**Preliminary Acceptance Punchlist**  
**El Paso County – Department of Public Works - Stormwater Section**

Project Name:	Lorson East F4
EDARP Filing Number(s):	SF198, CON1991
ESQCP Number:	ESQ1814
Attendees:	DPW SW: Natasha Grimaldo, Ben Jones, and Glen Reese DPW Development Services: N/A Developer: Did not attend
Date of Walk-Thru:	11-06-2023
Walk-Thru Number:	4 <sup>th</sup>

SHEET NUMBER
C7.1

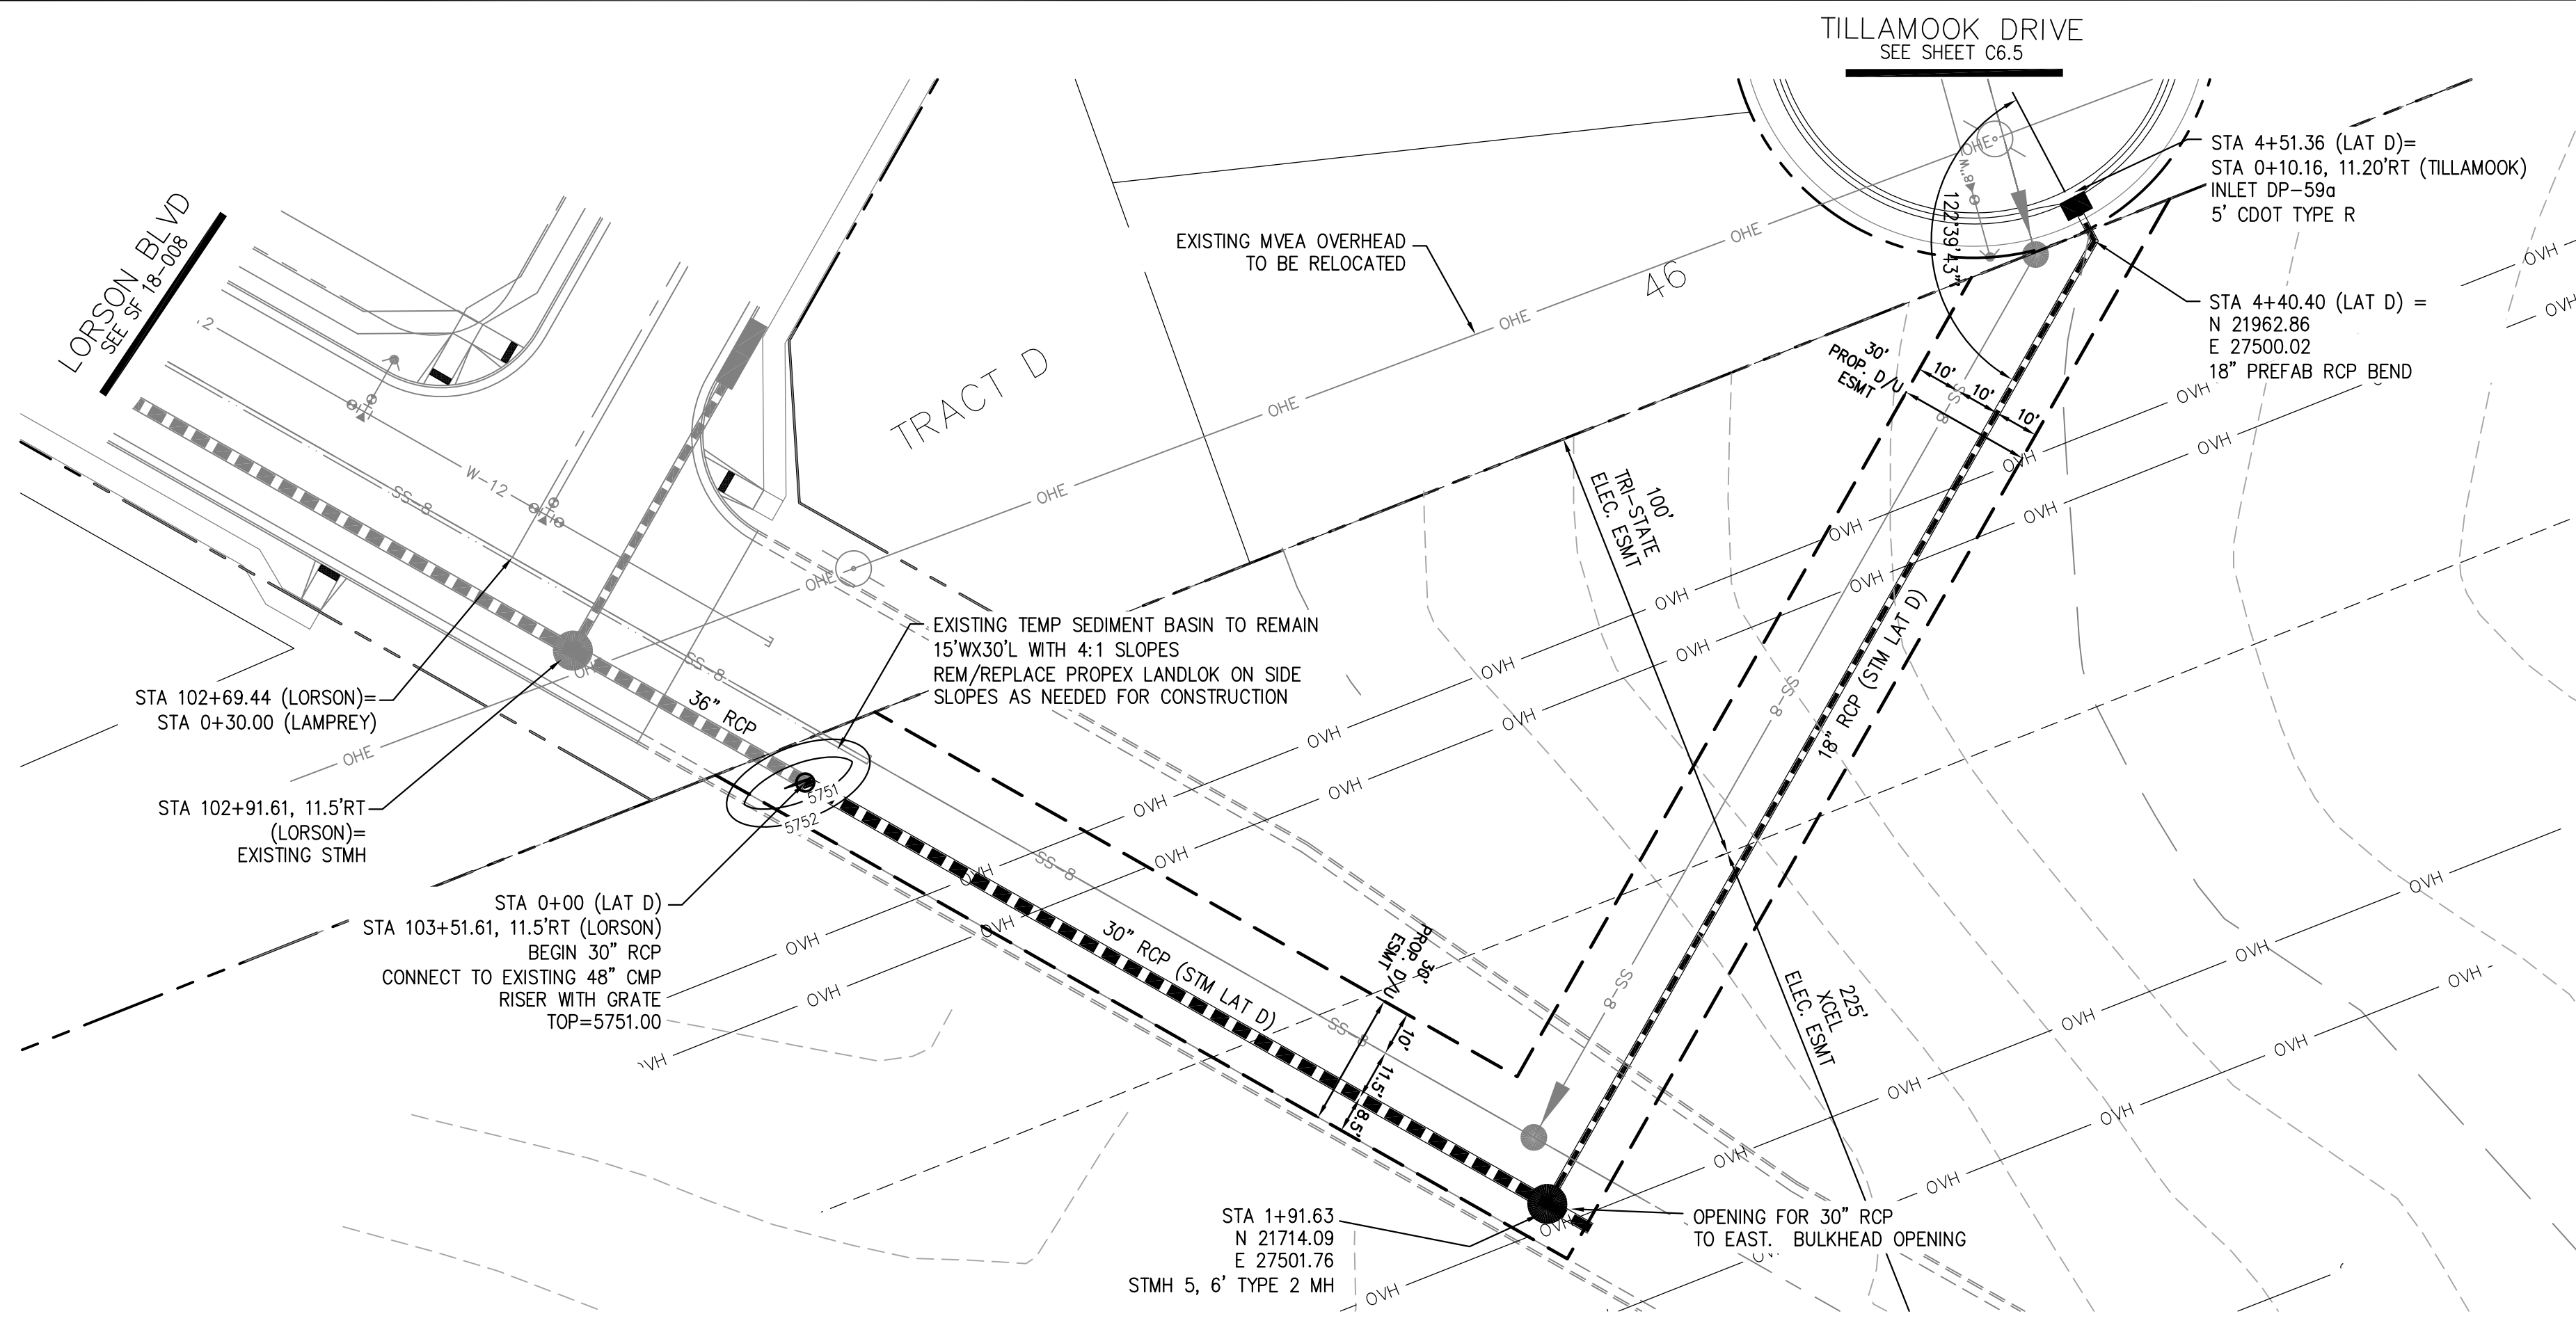
- Implement missing 9" D50 riprap 18" thick on fabric at RCP inlet or justify change in As-builts. Reference sheet C7.1 of the Construction Plans.
- Implement missing check dams (SD-3-62) or justify change within As-builts. Reference sheet C4.1 of the Final Grading and Erosion Control Plans.
- Remove temporary control measures from swale.

Photo 14: Substation Swale 2: Implement missing 9" D50 riprap 18" thick on fabric at RCP inlet or justify change in As-builts. Reference sheet C7.1 of the Construction Plans.

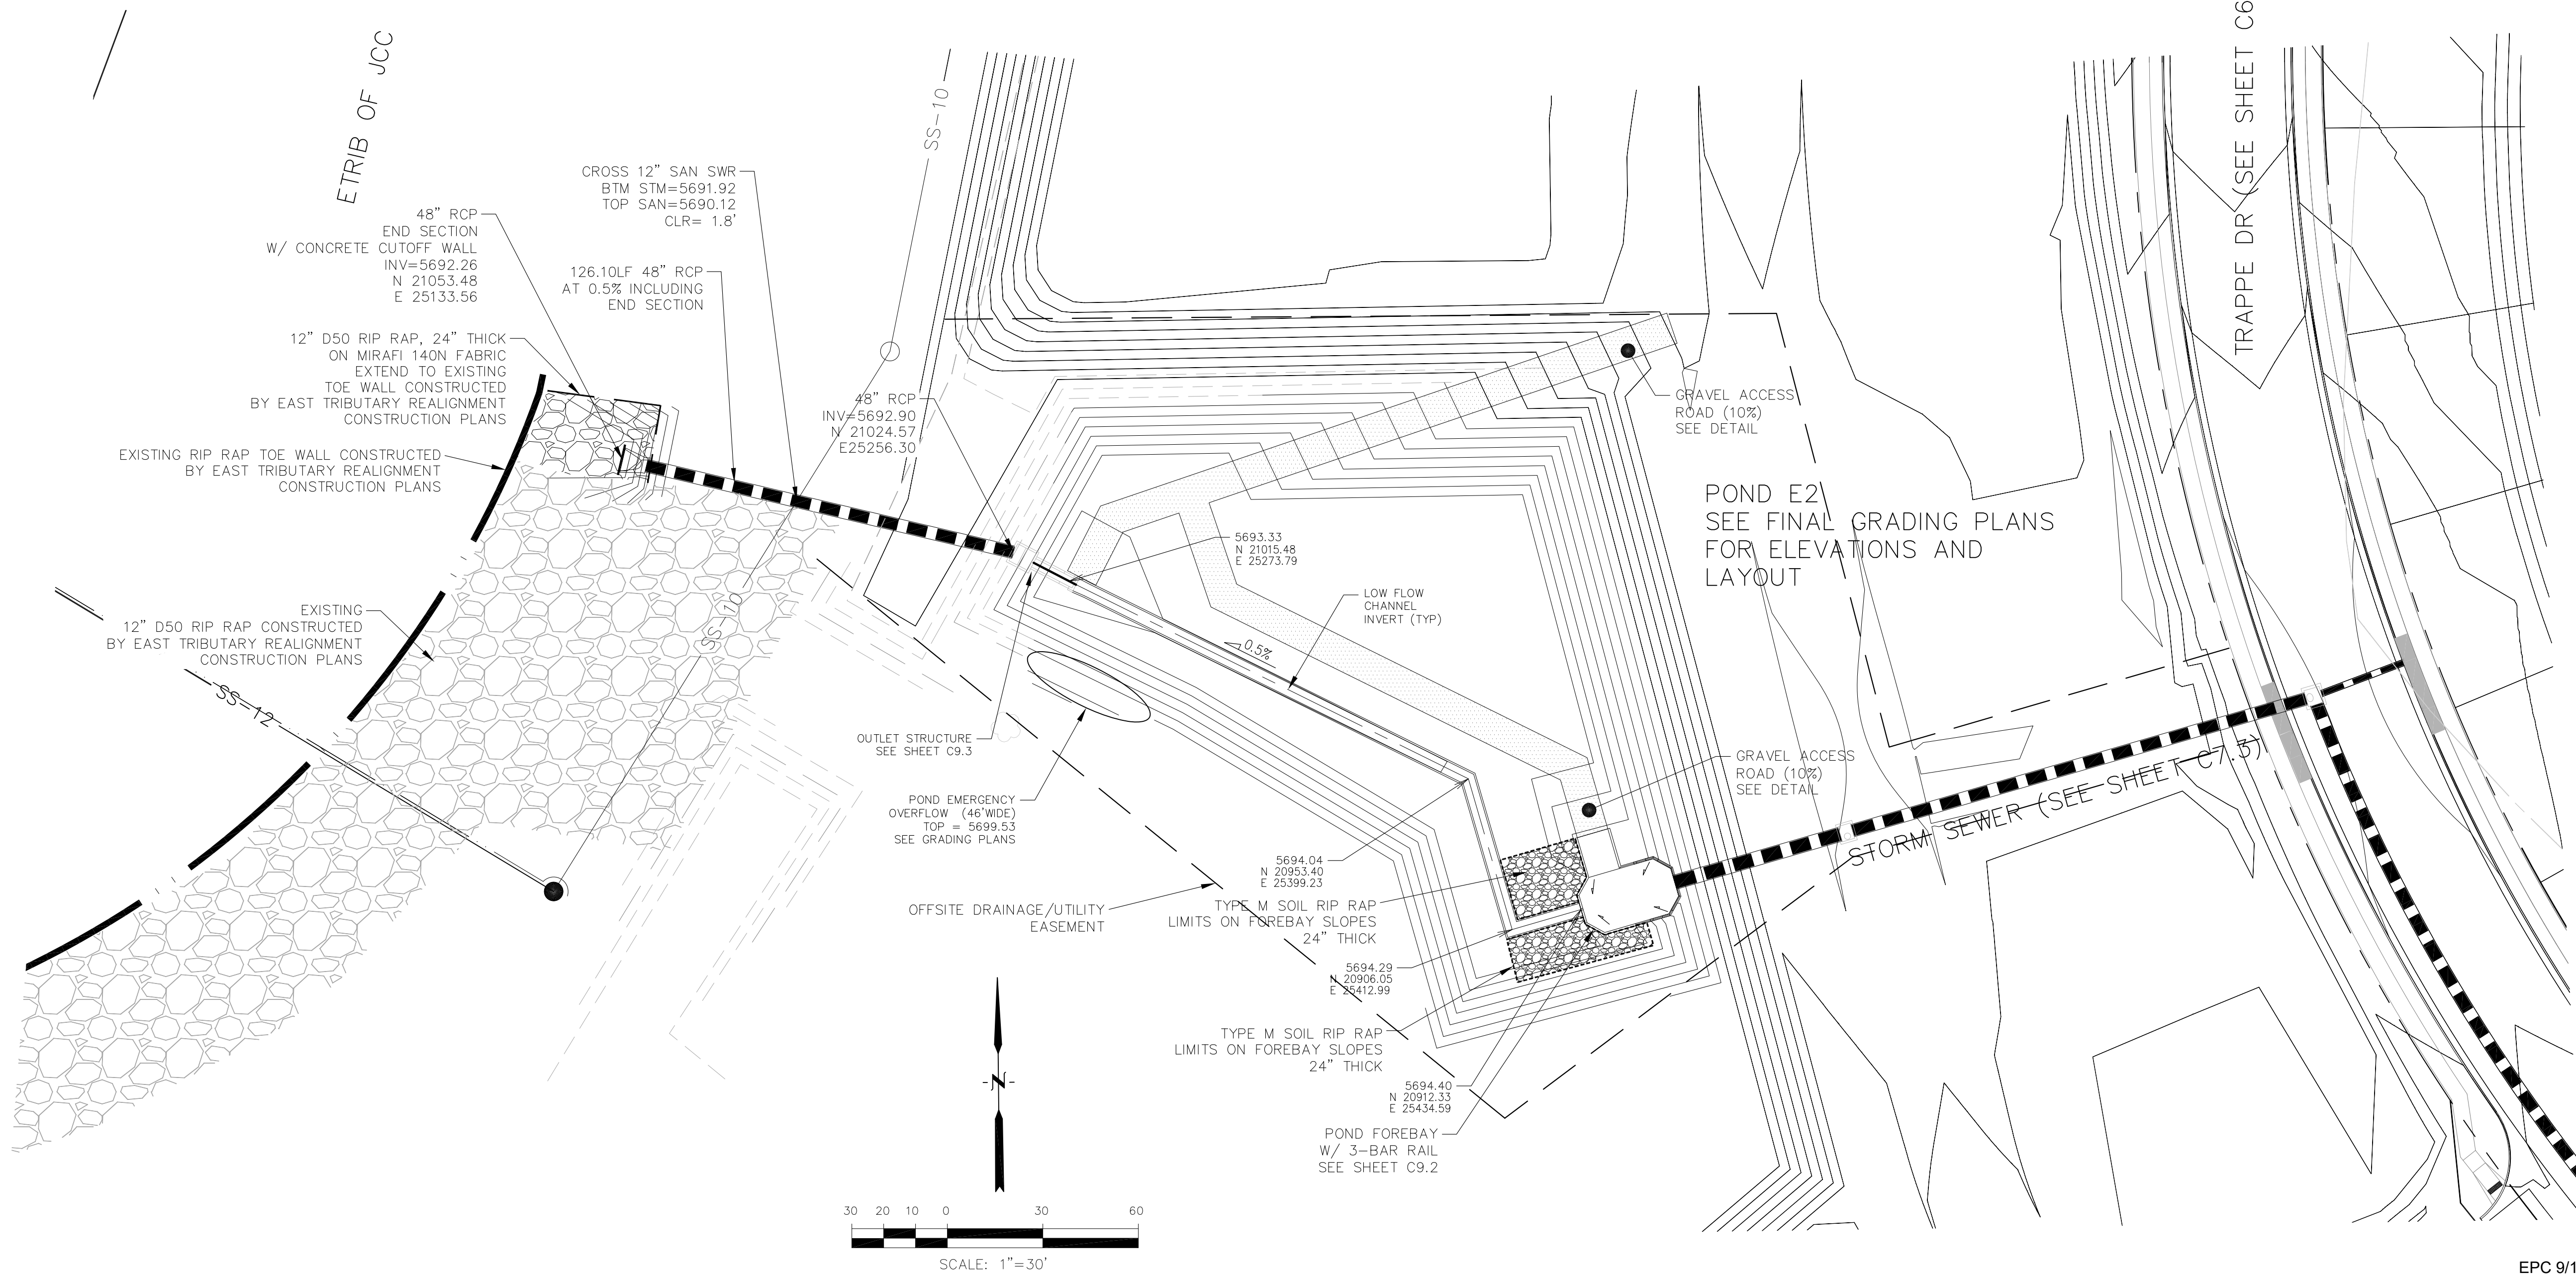
- Confirm caulk bead around orifice plate.
- Remove sediment and debris from outlet structure micropool.
- Implement missing bolts on outlet structure top grates.
- Confirm installation of 24" thick soil riprap at east forebay. Reference sheet C9.1 of the Construction Plans.
- Remove excess sediment from maintenance access road within pond bottom and reestablish road base along trickle channel. Access road should consist of 12" thick class 6 aggregate. Reference sheet C9.1 of the Construction Plans.
- Repair rilling along maintenance access road. Rilling could worsen and will be required to be repaired at Final Acceptance.

Photo 9: Confirm installation of 24" thick soil riprap at east forebay. Reference sheet C9.1 of the Construction Plans.

Photo 10: Remove excess sediment from maintenance access road within pond bottom and reestablish road base along trickle channel. Access road should consist of 12" thick class 6 aggregate. Reference sheet C9.1 of the Construction Plans.
